Church End House, 44 Totteridge Village, Whetstone, London N20 8PR

PLANNING STATEMENT IN SUPPORT OF NON-MATERIAL AMENDMENT TO PLANNING PERMISSION GRANTED ON APPEAL APP/N5090/D/20/3257489 FOR THE ERECTION OF A NEW GARAGE WITH RESIDENTIAL ACCOMMODATION IN THE ROOF SPACE FOR USE ANCILLARY TO THE MAIN HOUSE FOLLOWING THE DEMOLITION OF EXISTING GARAGE.

NON MATERIAL AMENDMENT REQUIRED:

PROPOSED FRONT ELEVATION

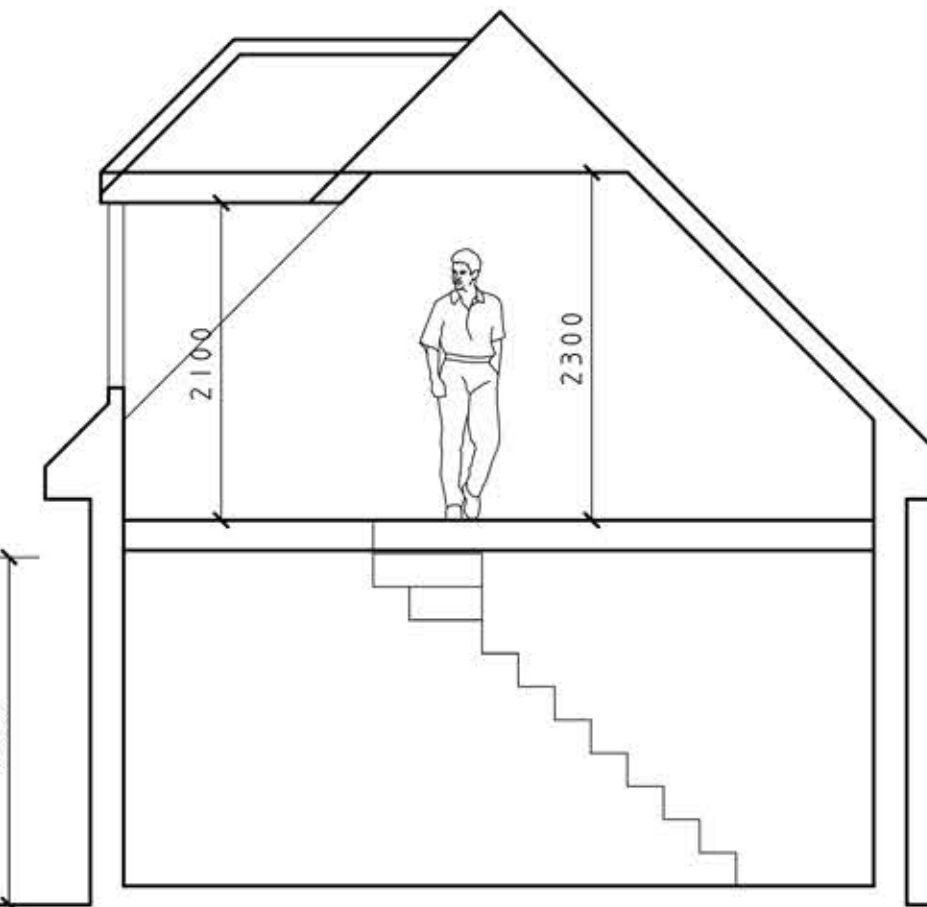
OMIT ONE GARAGE DOOR AND REPLACE WITH WINDOW TO MATCH THAT APPROVED AT ROOF LEVEL. (WINDOW DETAIL APPROVED VIA CONDITION O3 TO BE FOLLOWED)

The proposed non-material amendment does not involve any increase in the size of the building it is purely an elevational change replacing a garage door with a matching window to the upper floor.
